CITY OF ALBUQUERQUE

Re: Palomas Peak
8310 Palomas Ave 87109
Traffic Circulation Layout
Engineer's/Architect's Stamp 11-01-2019 (D19D031)

Based upon the information provided in your submittal received 01-09-2020, the above referenced plan cannot be approved for Building Permit until the following comments are addressed:

**A1** SITE PLAN  
1" = 20'-0"

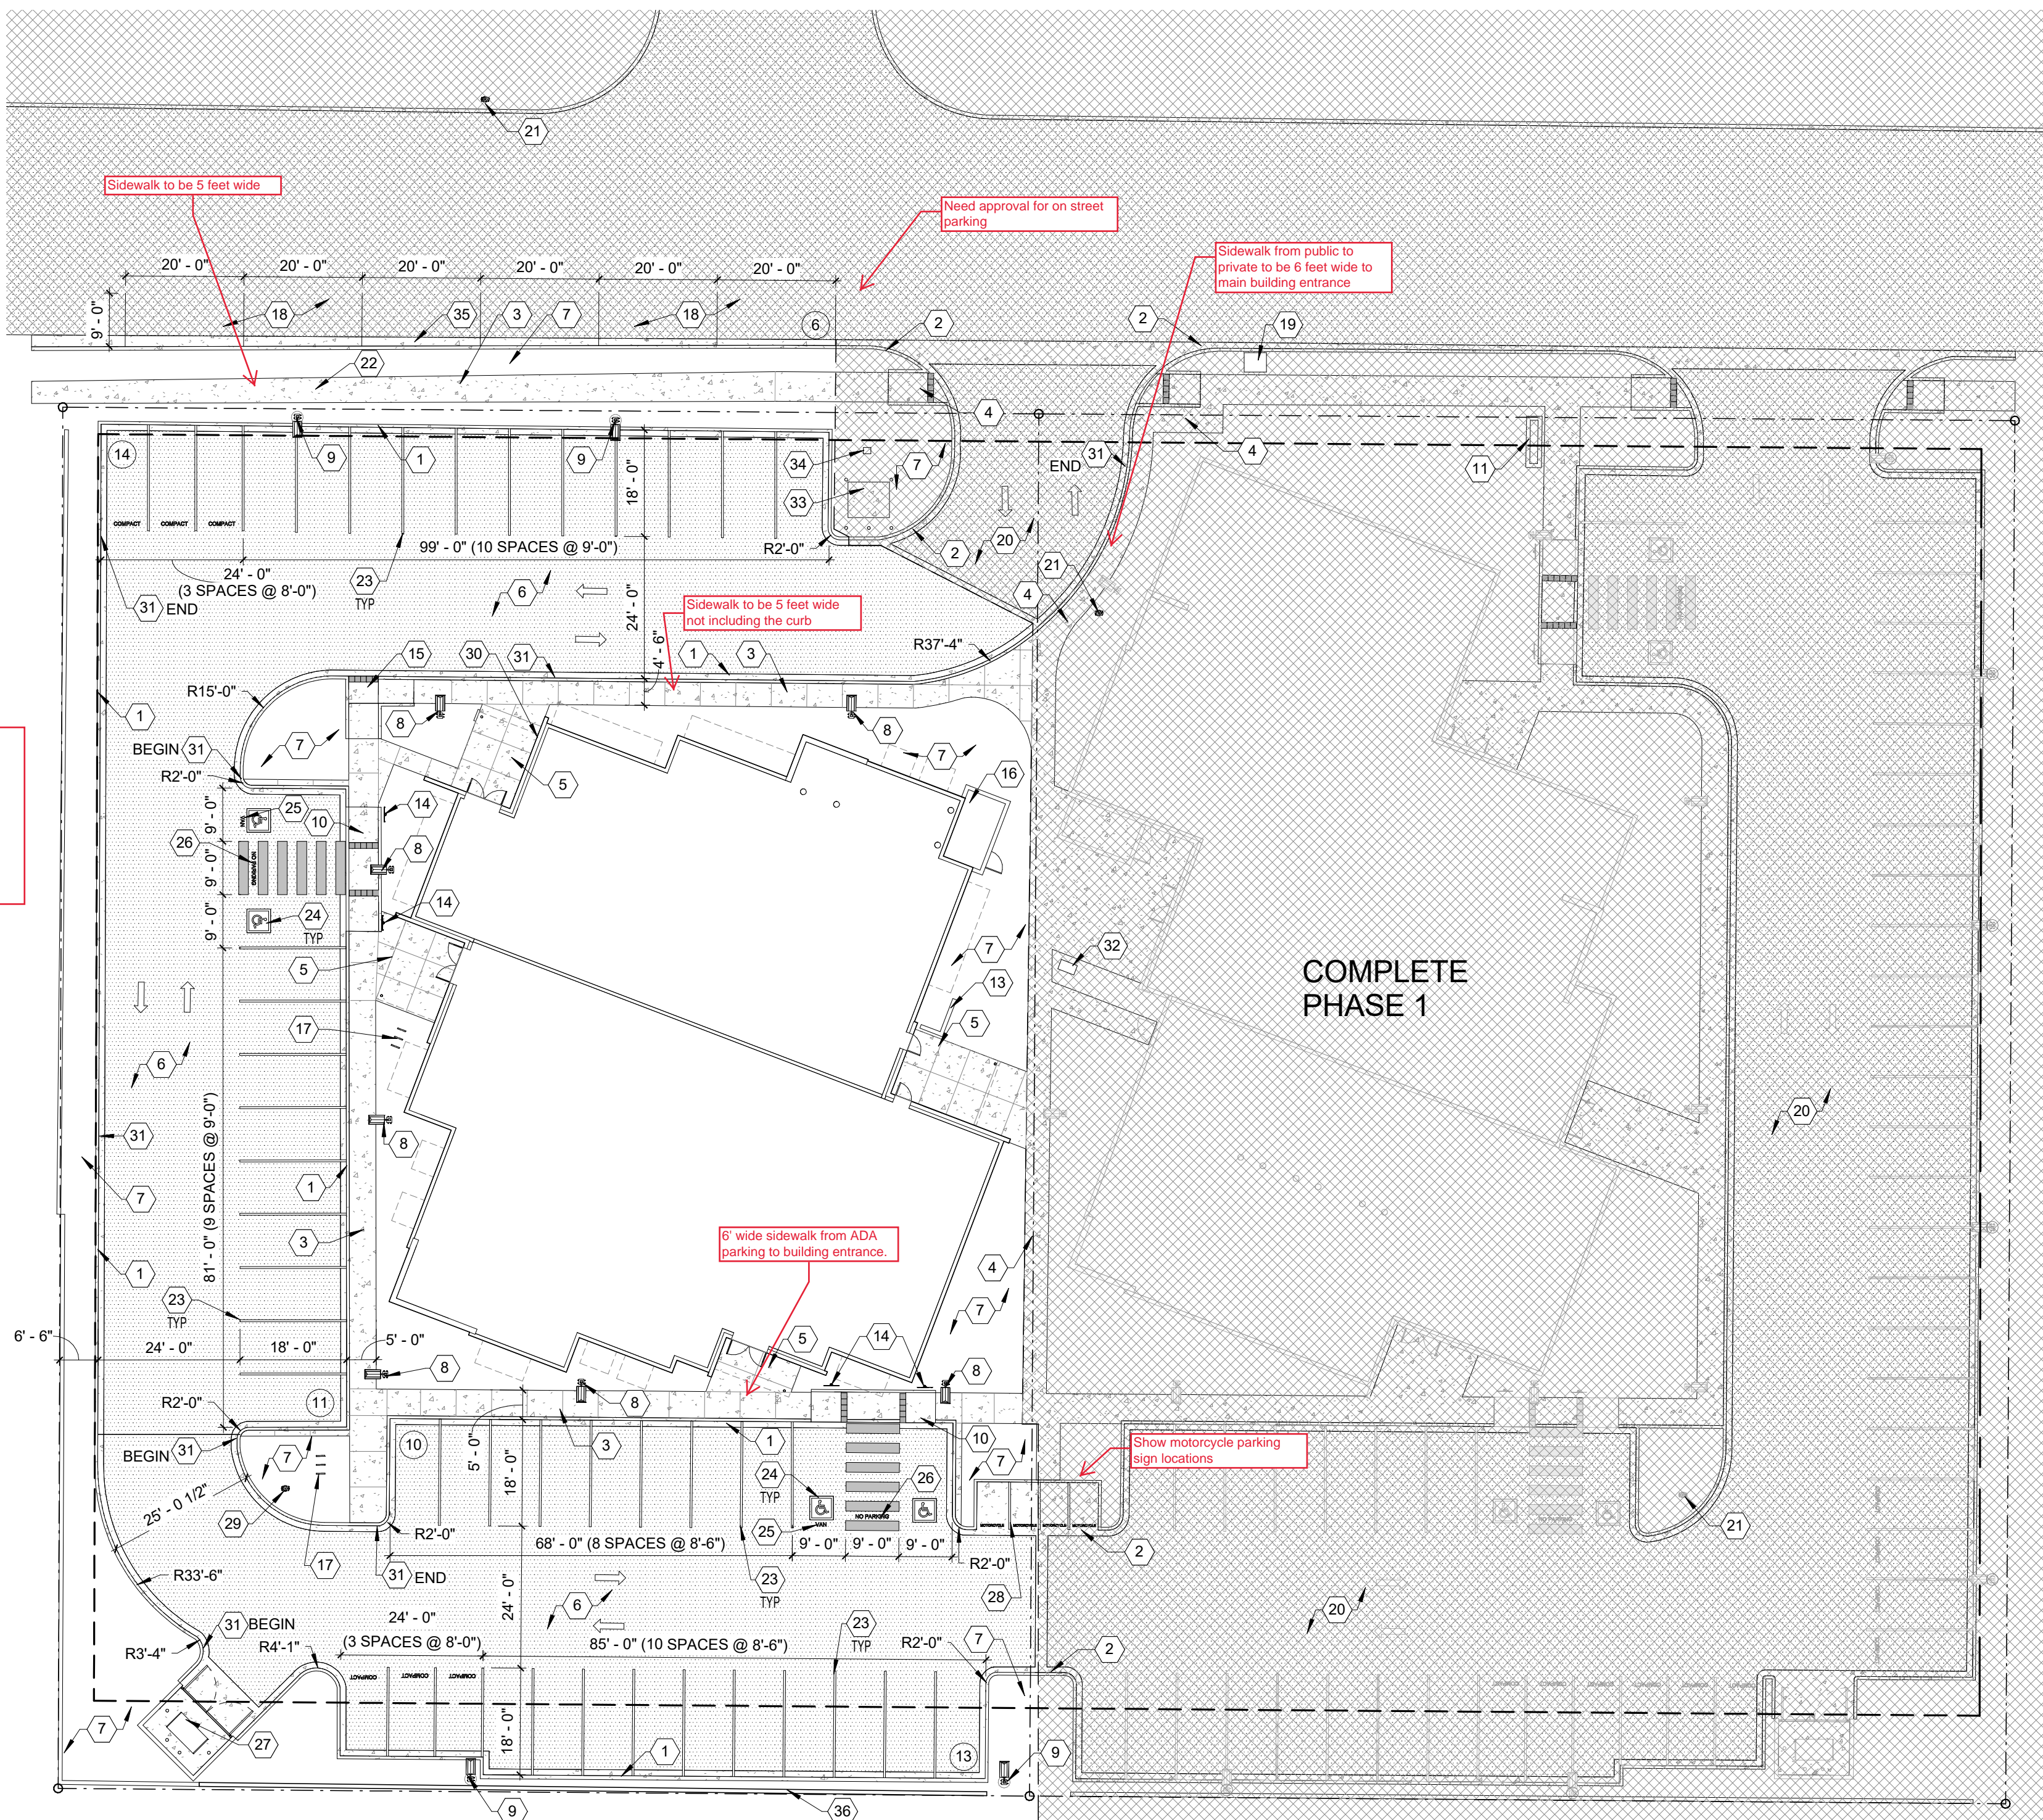
1. I am attaching the on-street requirements in terms of dimension.
2. Please list the width and length for all proposed parking spaces. Some dimensions are not shown.
